DOC19/839420-4

Date: 22/10/19

SSD-9143 – Poultry Processing Mixed Use Development EIS at 52 Sinclair St, Goulburn – EPA Comments

PROPOSED LAYOUT PLAN  
 PROPOSED PROCESSING FACILITY  
 52 SINCLAIR STREET,  
 GOULBURN  
 WOODLAND RIDGE POULTRY PTY LTD

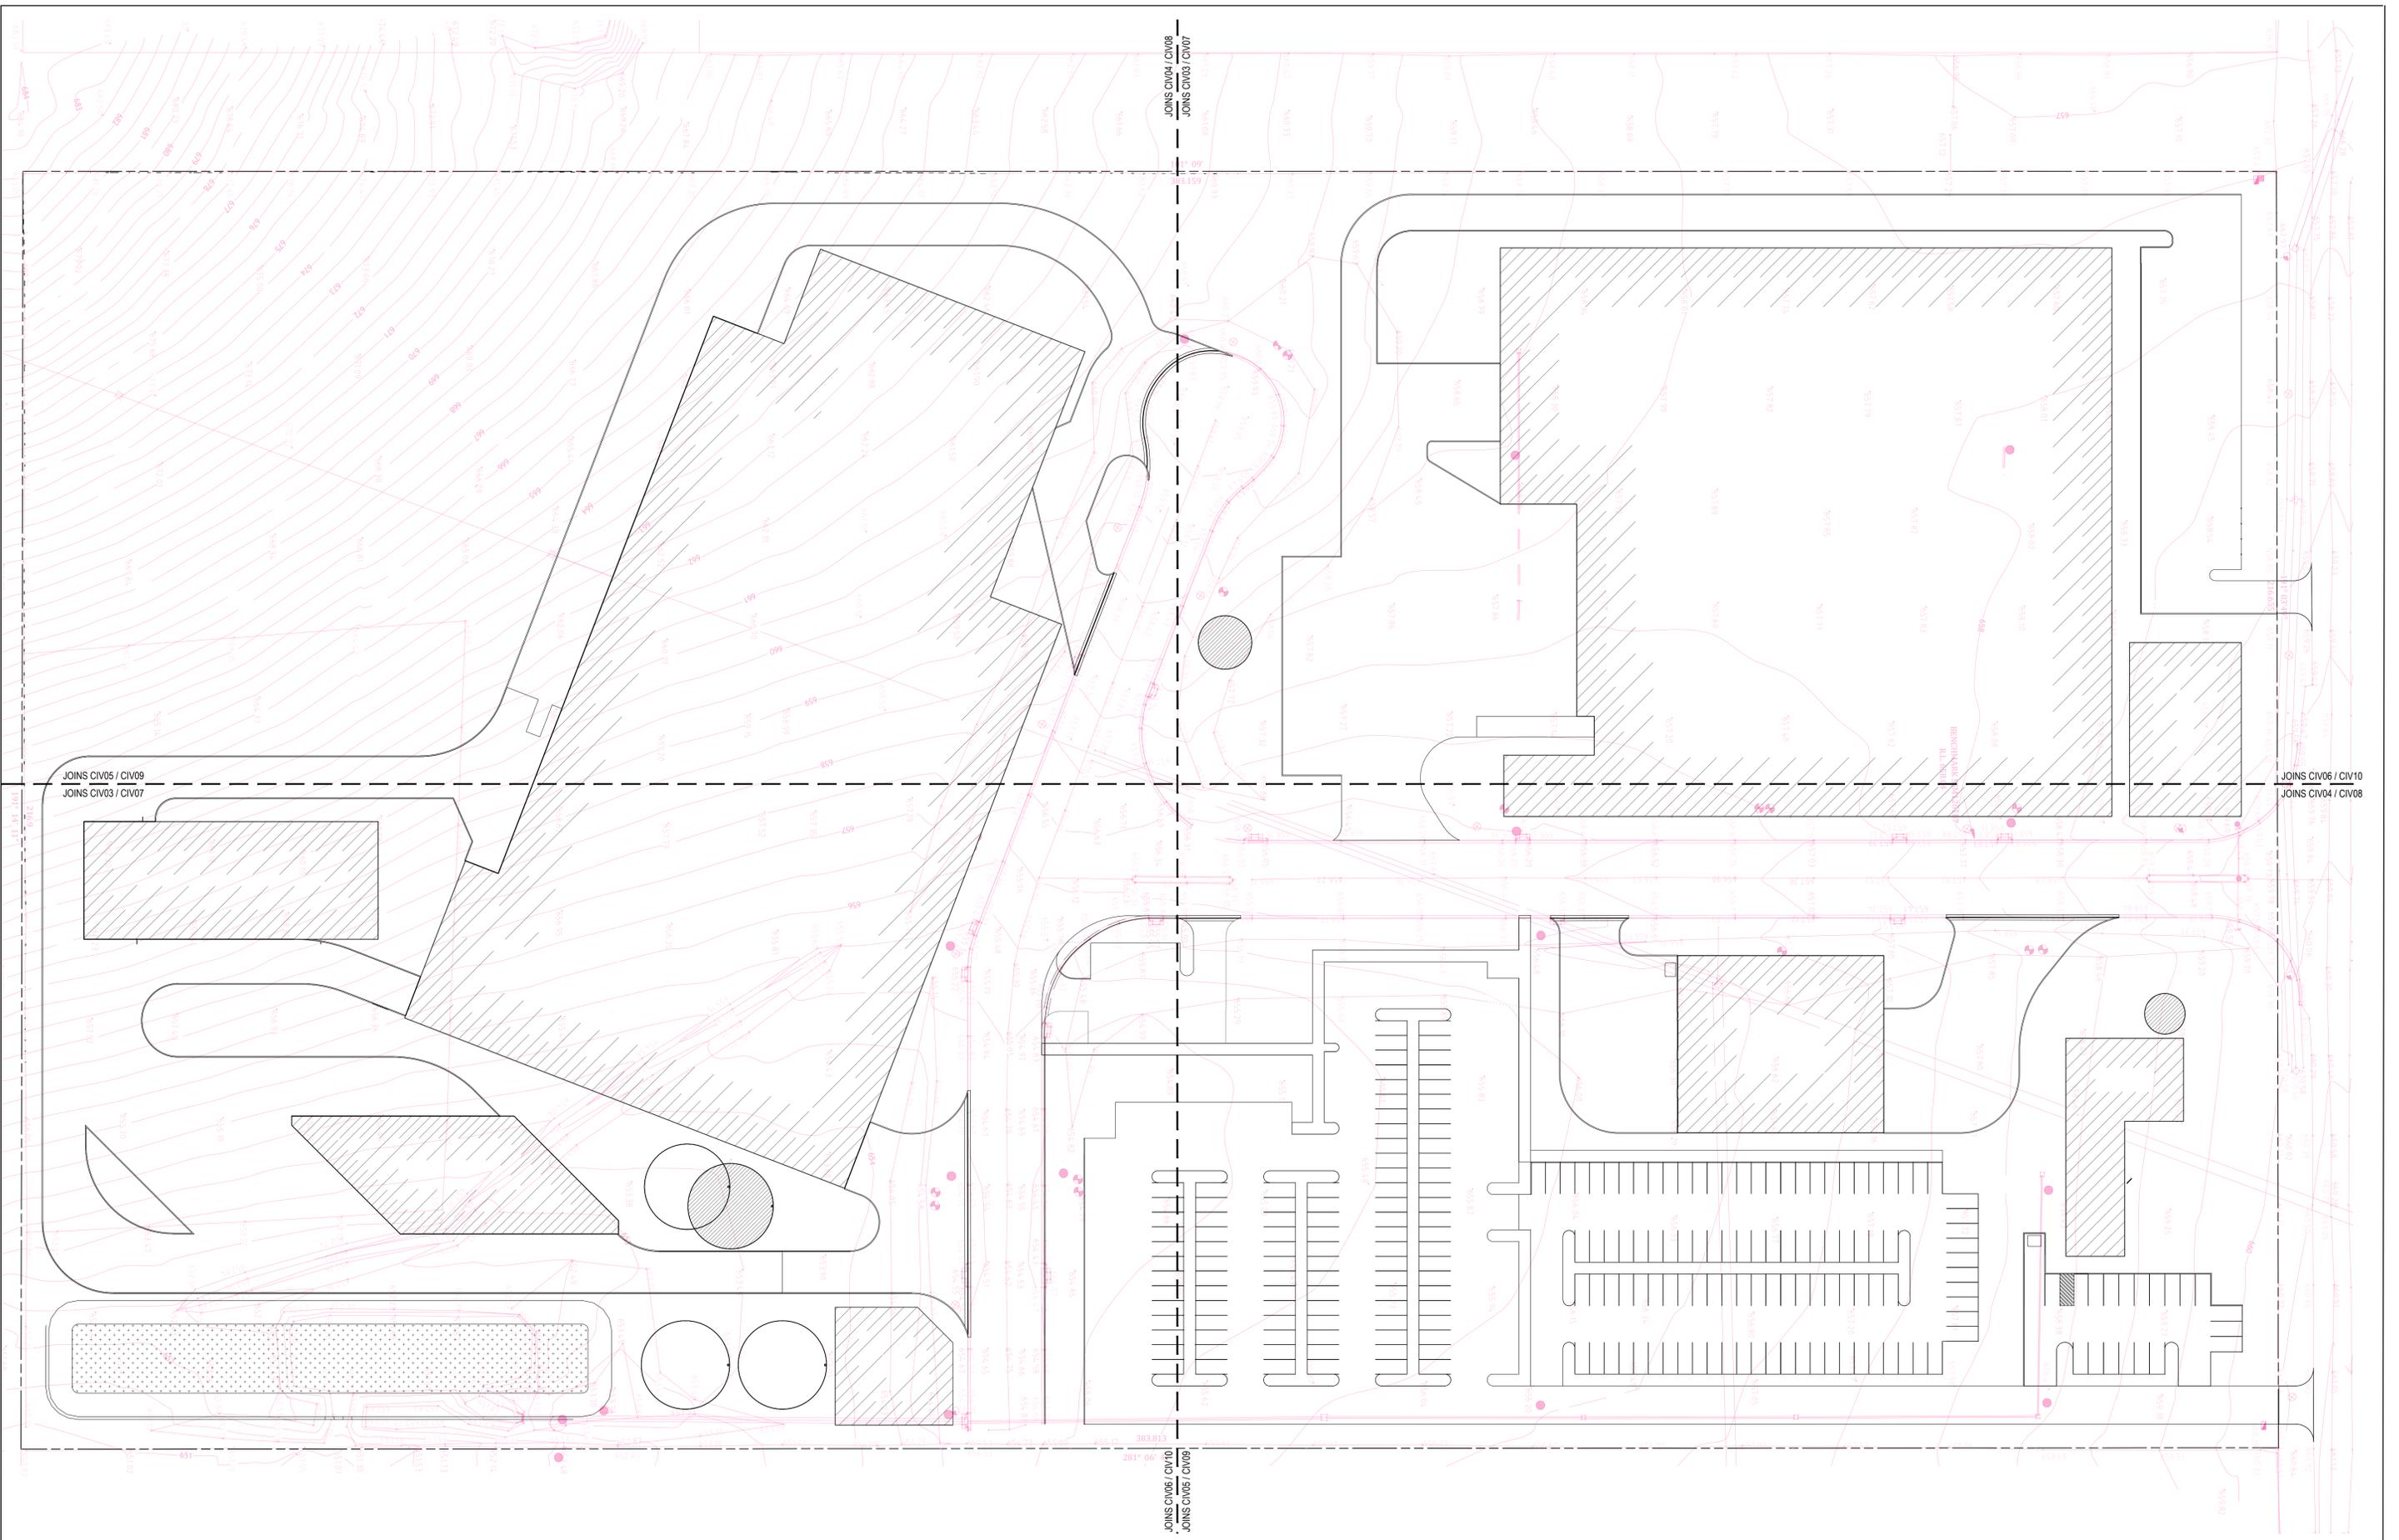
The AQIA states the biofilter will be located adjacent to the by-products processing plant, however, the biofilter is not located on the proposed layout for the proposed site (EIS Figure 2). Given that the biofilter is one of the three sources of odour, and the close proximity of the nearest sensitive receptor, **the EPA recommends that the location of the biofilter should be included in the description of the proposed site to assess the potential offsite odour impacts.**
